# Technical Note

The Old Cottage Lidsey

TN/SGR/TOC/101117-4\_V2

### West Sussex County Council Additional Response (AL/20/18/OUT)

Project		
OLD COTTAGE LIDSEY		
New Access Design		
Drawn	Date	Scale (at A3)
TE	19/07/2018	1:500
Doc no.	Revision No.	
OCL/SR/701	C

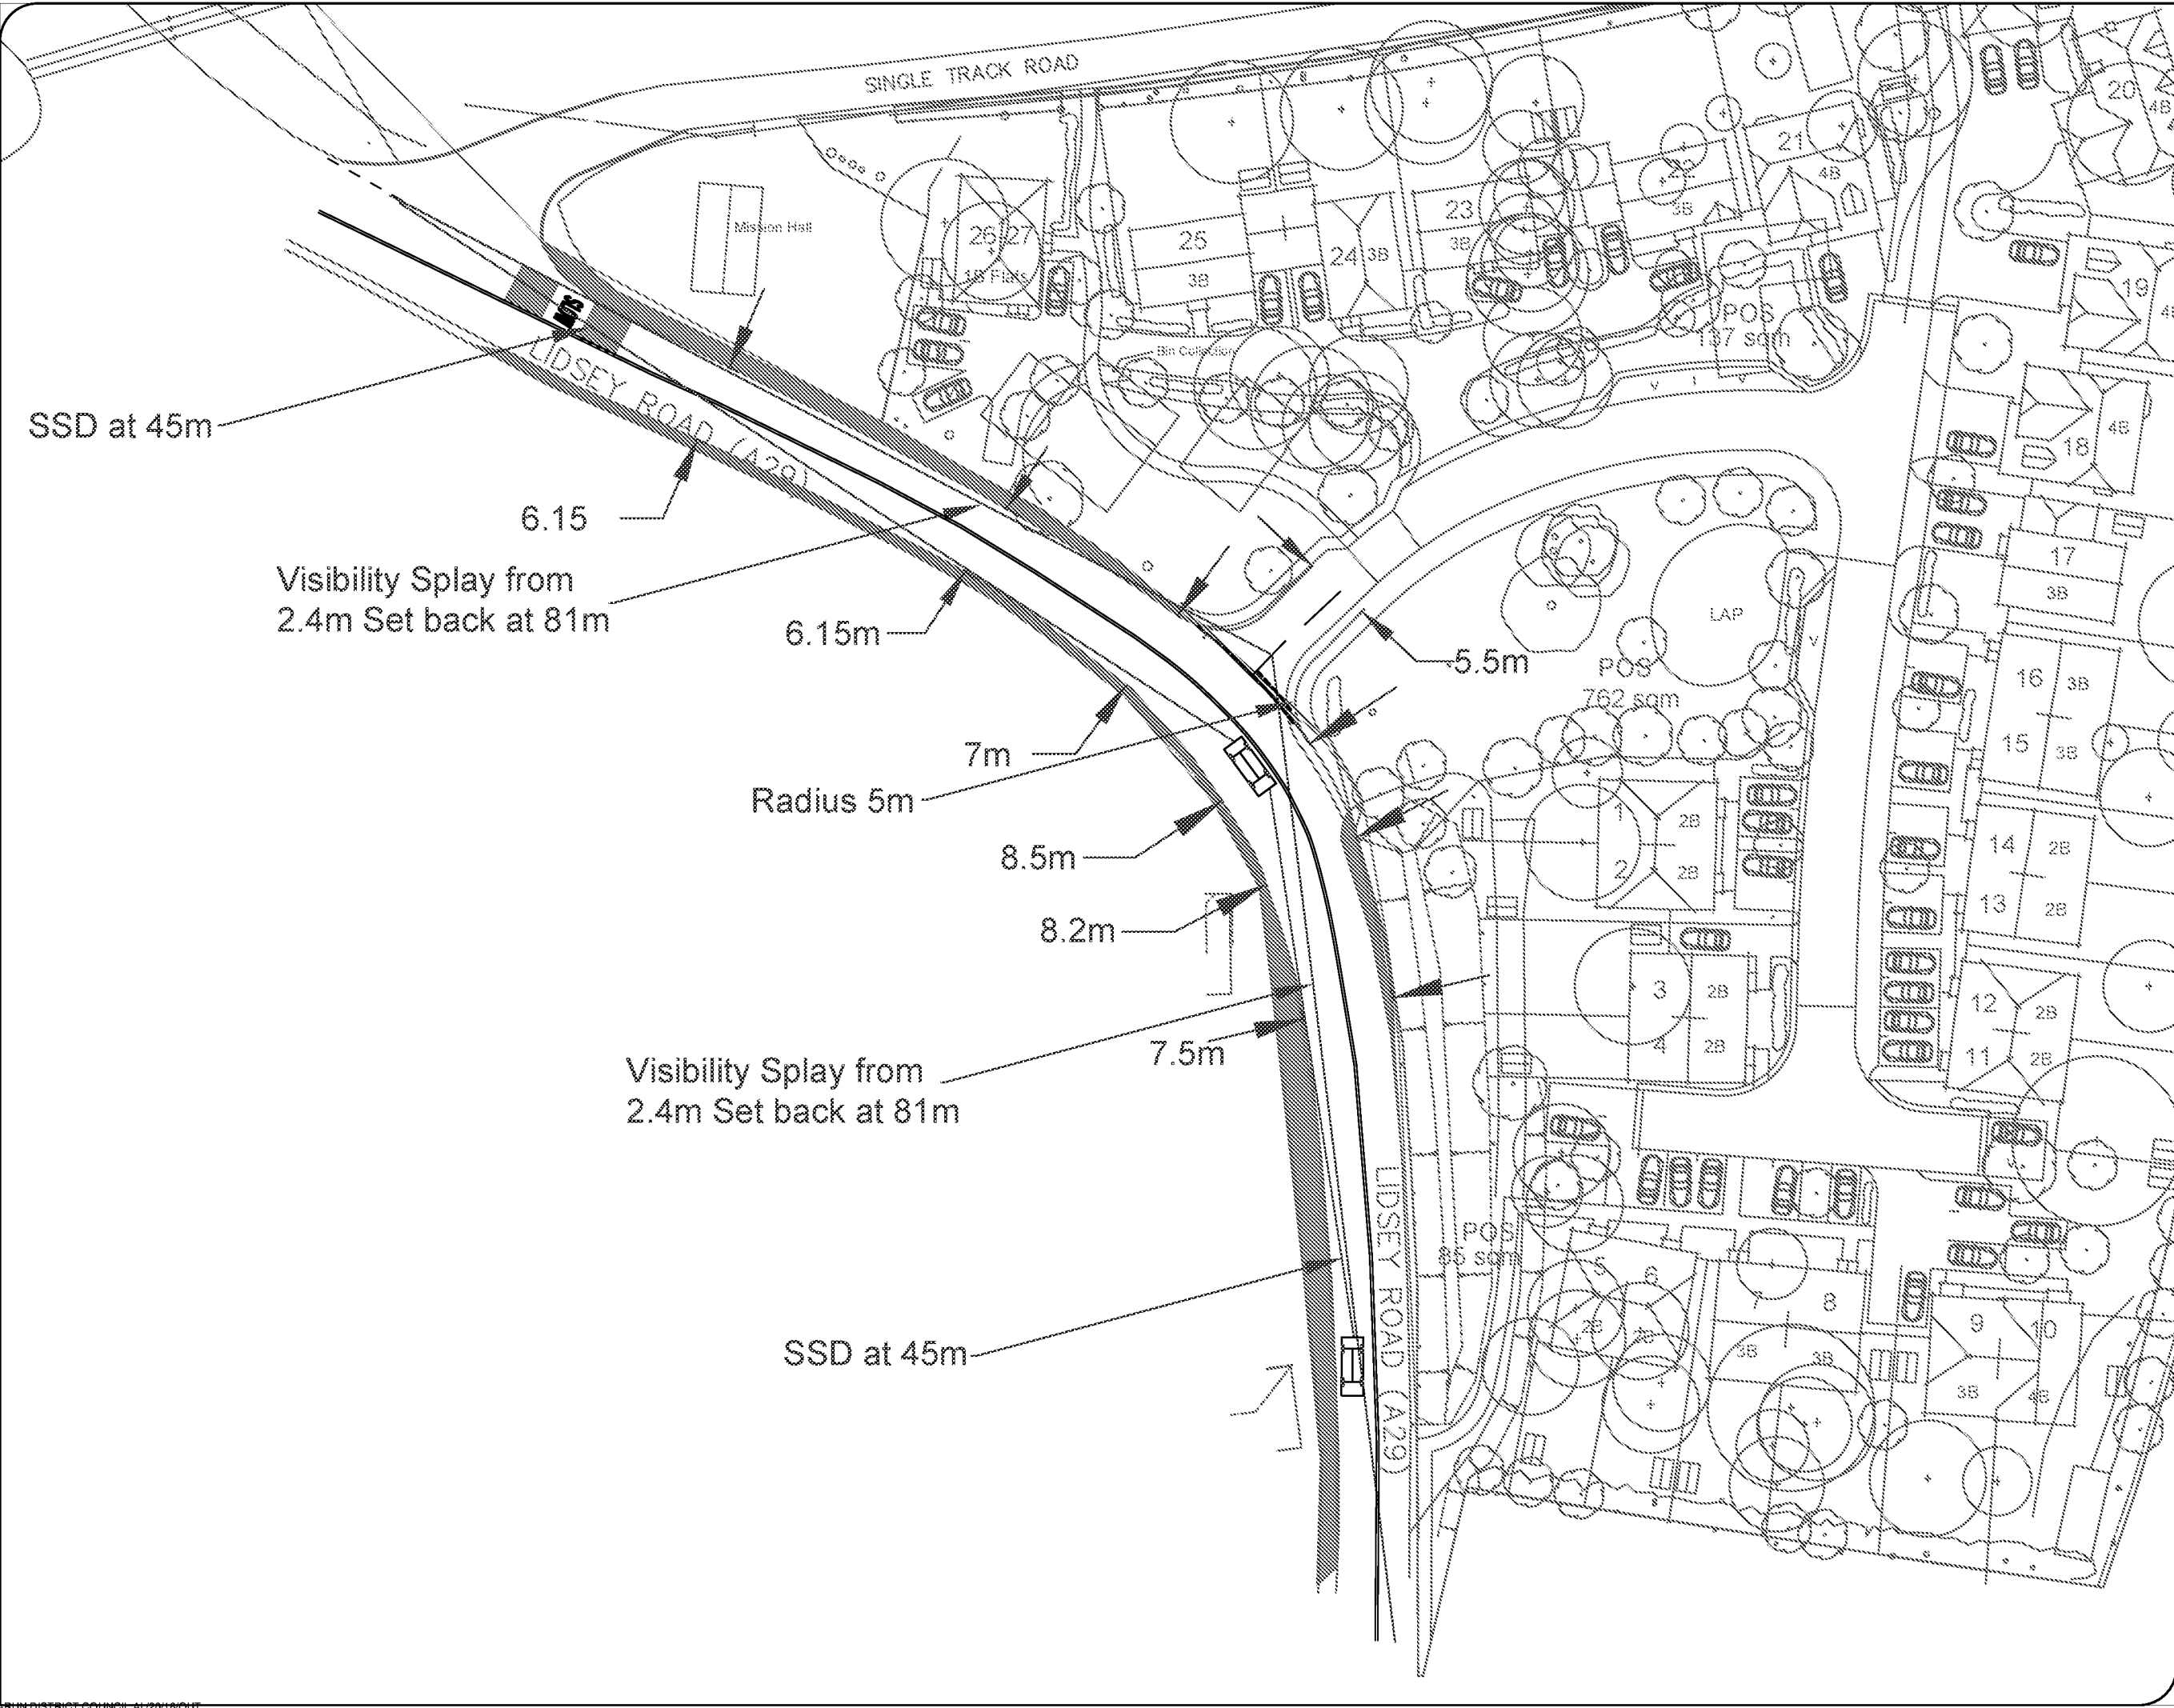
It is not clear from the current plan (OCL/SR/701 Rev. C) what the red colouring is supposed to show. As such, a plan showing what the County Council currently consider to be the extent of public highway is attached to this reply in order to assist the applicant when plotting the visibility and SSD splays.

- Also previously, a design commentary was requested. Drawing OCL/SR/701 Rev. C attempts to show design parameters taken from MfS2. Although please note that it will need updating in-light of the SSD comments made earlier.

- A Design Commentary setting-out how the design complies with guidance and/or design standards. Drawing OCL/SR/701 Rev. C attempts to show design parameters taken from MfS2. Although please note that it will need updating in-light of the SSD comments made earlier.

- 3.1 Updated plan OCL/SR/701 rev D is attached, as Appendix 2, which illustrates the forward visibility afforded to vehicles passing and entering the site. The achievable Sight Stopping Distances (SSDs) are noted as a minimum of 70metres to the south and 81metres to the north. These exceed the distances noted in the Local Highway Authority's comments.

- 3.2 The existing adopted highway and realigned verge are annotated in red shading. There was an observation regarding the position of cars waiting to turn right into the site and the annotation of the SSDs. Using a scale rule, and professional judgement, it is clear that the available visibility, no matter where a car is waiting to turn, exceeds the 67metre minimum noted by the Local Highway Authority. This visibility is achievable within land that is part of the adopted highway. It is apparent that providing additional plans demonstrating innumerable versions of achievable SSDs to determine that the access will be safe is unnecessary.
